# DDA ASSESSMENT REPORT

New Primary School at Gregory Hills  
28 Wallarah Circuit, Gregory Hills NSW 2557

Prepared for: SINSW | Issue date: 5 October 22

DRAWING TITLE
GA - GROUND LEVEL

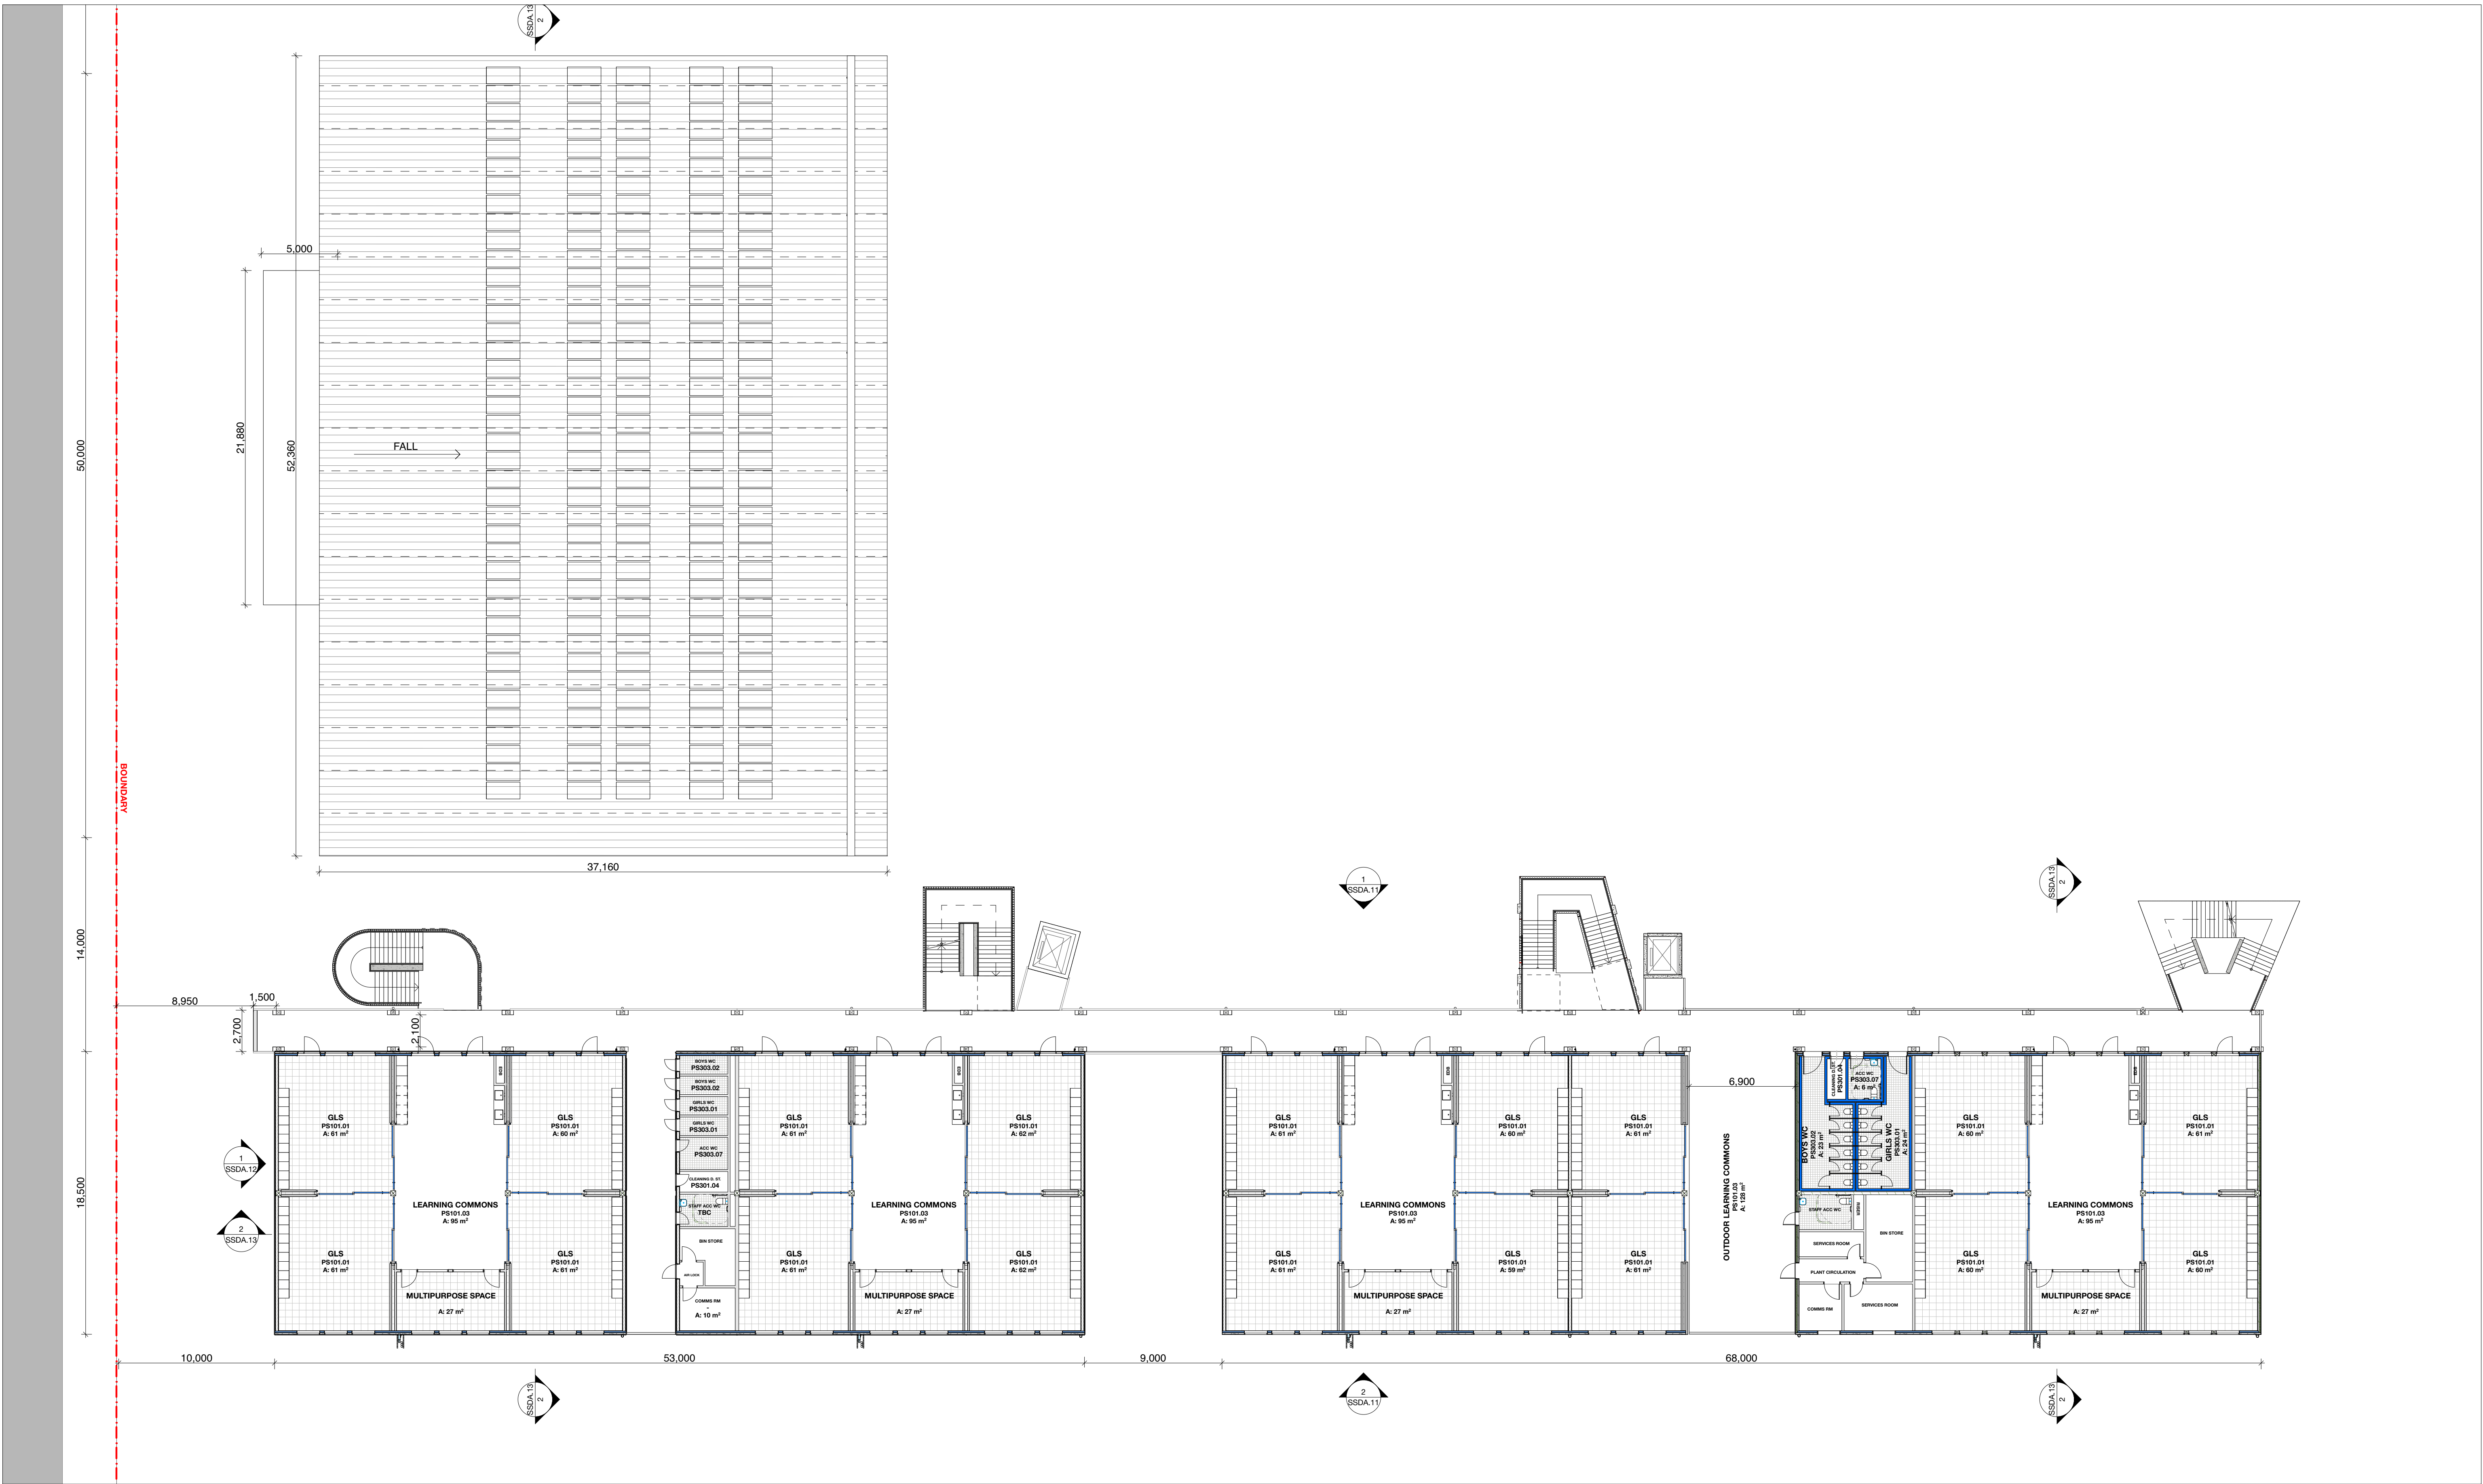
It is noted that the accessible sanitary facility is not located adjacent to the bank of toilets on the Ground floor level of Block A. Architect to note and amend the plans accordingly.
